Job No. 162652

March 12, 2019

Re: Response to El Paso County Review Comments  
Redtail Ranch Subdivision  
Sanctuary Pines Dr  
Parcel No's: 5209002006, 5209002008, 5209000129 and 5209000128  
El Paso County, Colorado

## **GEOLOGY AND SOILS REPORT and Wastewater Study with Detention Storage Criteria**

SHEET No. FIG-3

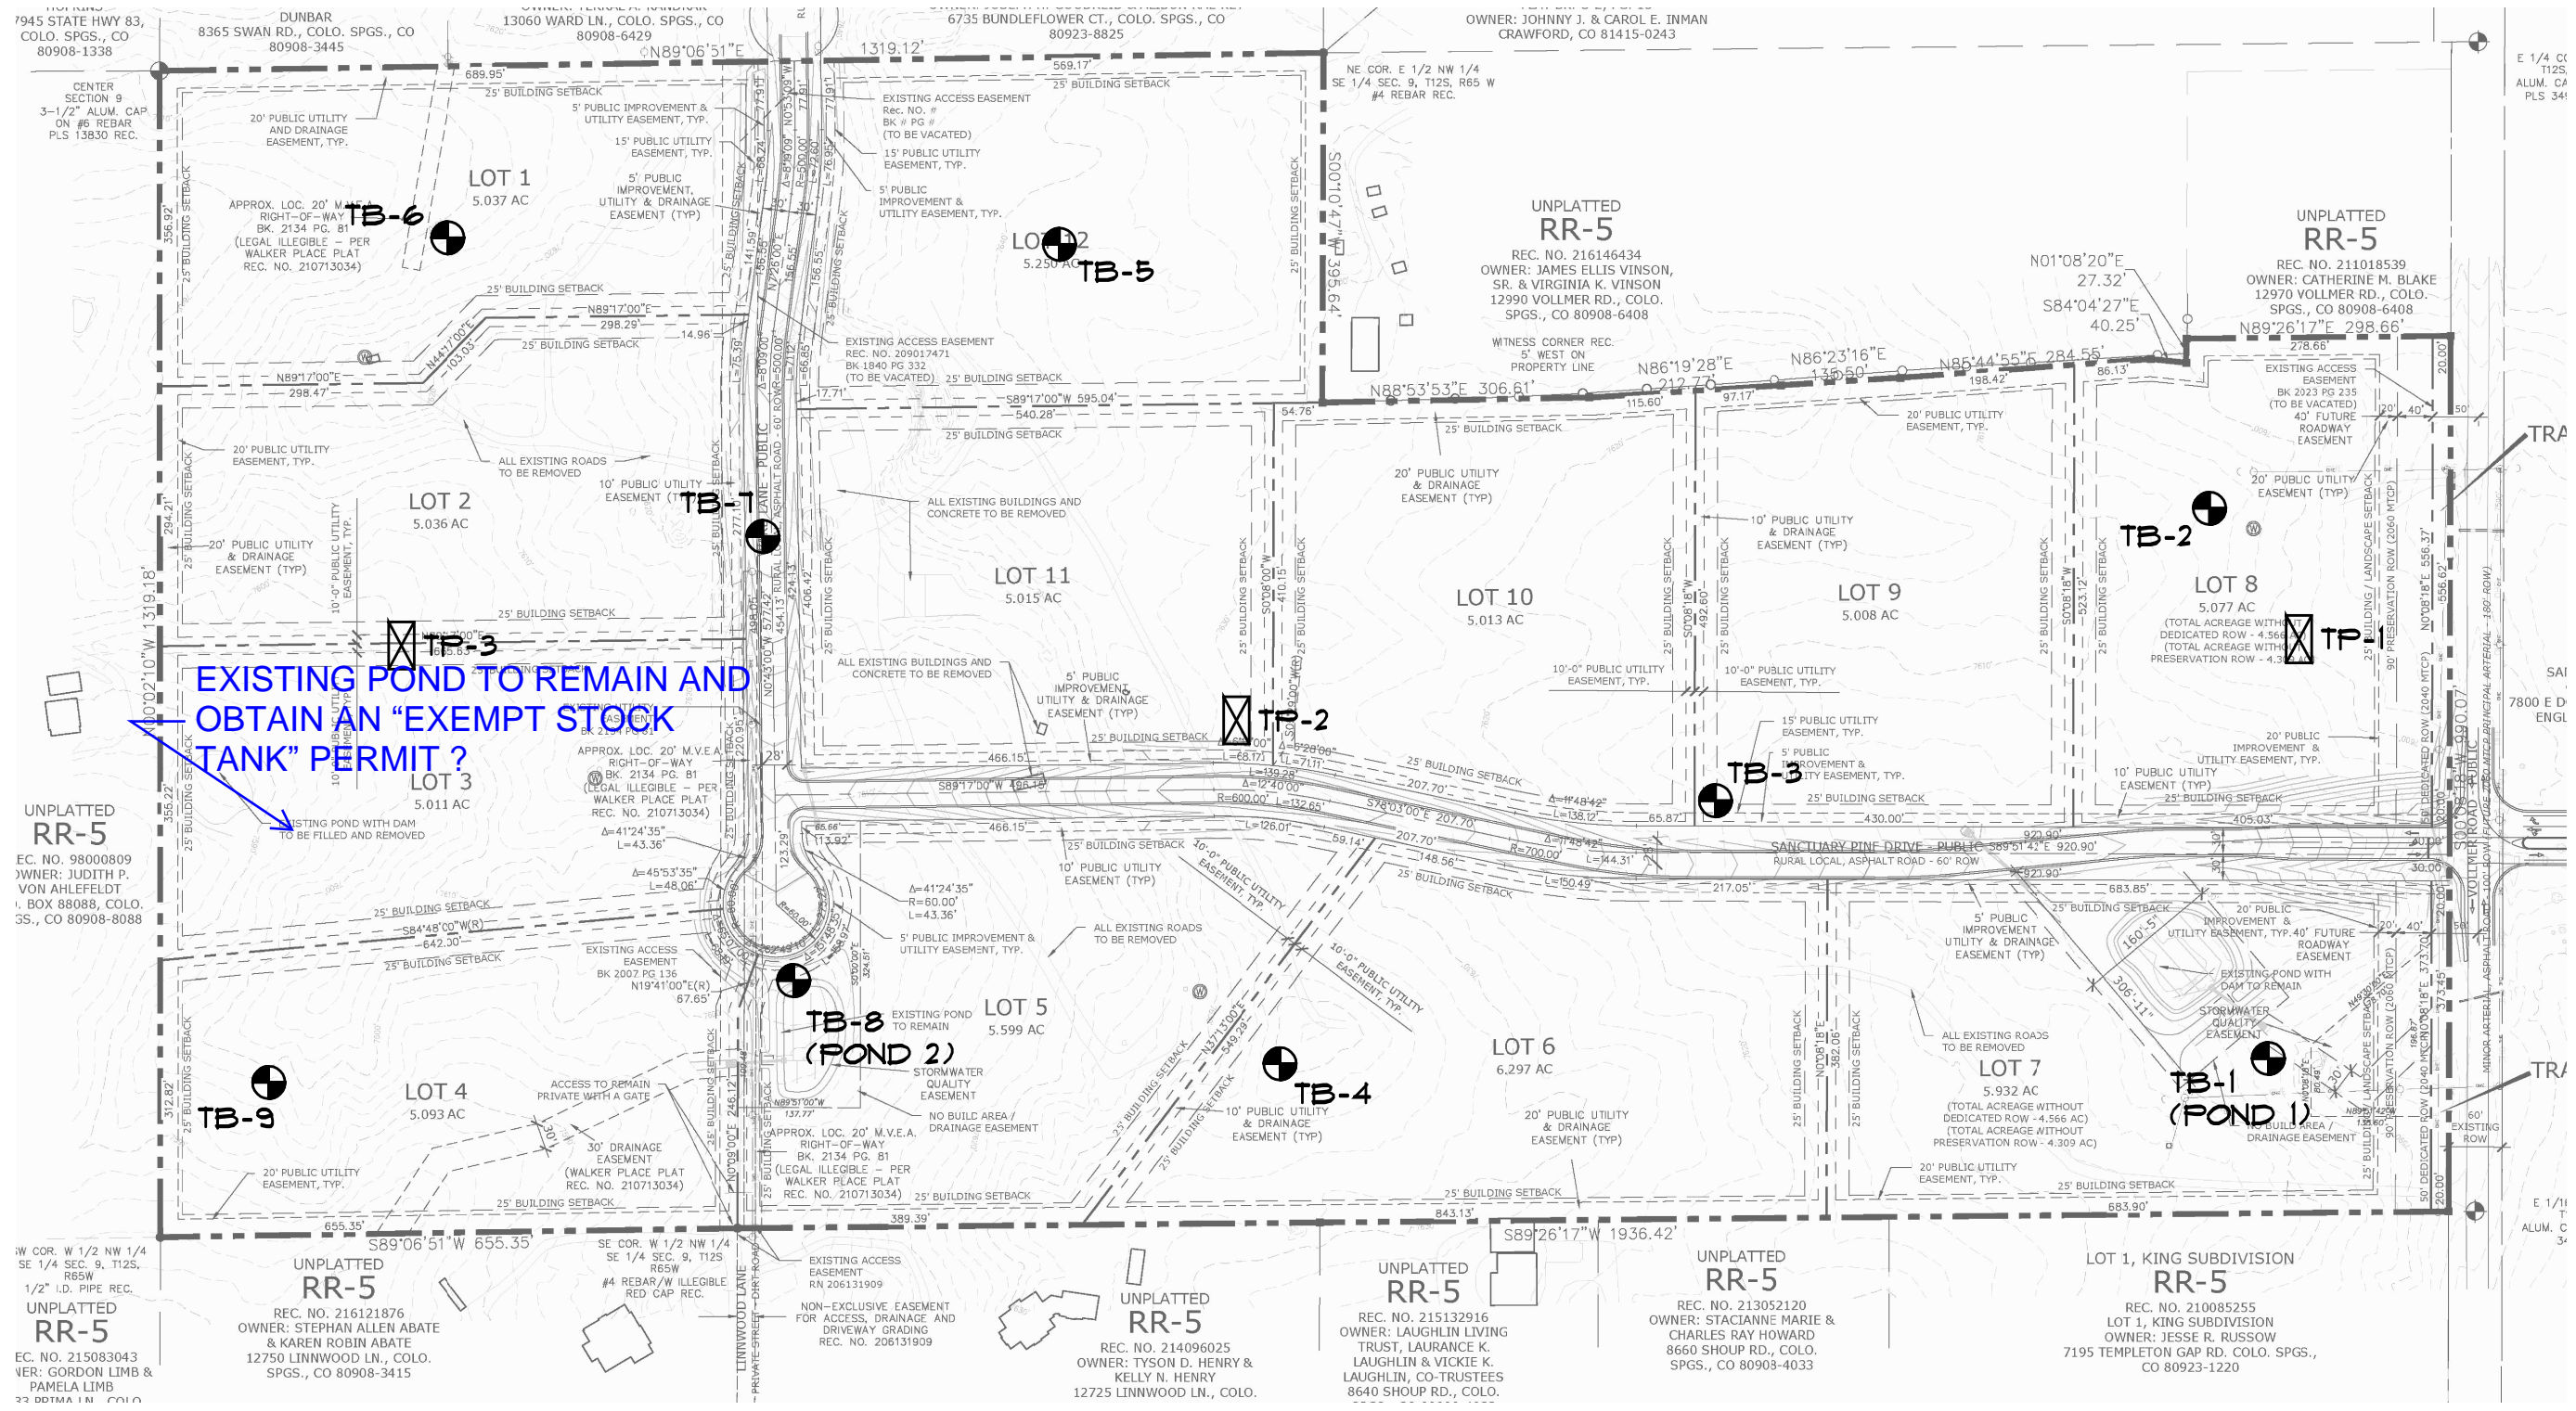
- **EPC County Comment:** *"Existing pond to remain and obtain "Exempt Stock Tank" permit?" as denoted on RMG's Figure 3, Concept Plan and Figure 4, Concept Plan with Test Boring and Test Pit Location Plan.*

RMG Response: It is RMG's understanding that the pond is to be filled in on Lot 3, as noted on the revised Figure 18, General Geology and Engineering Map.
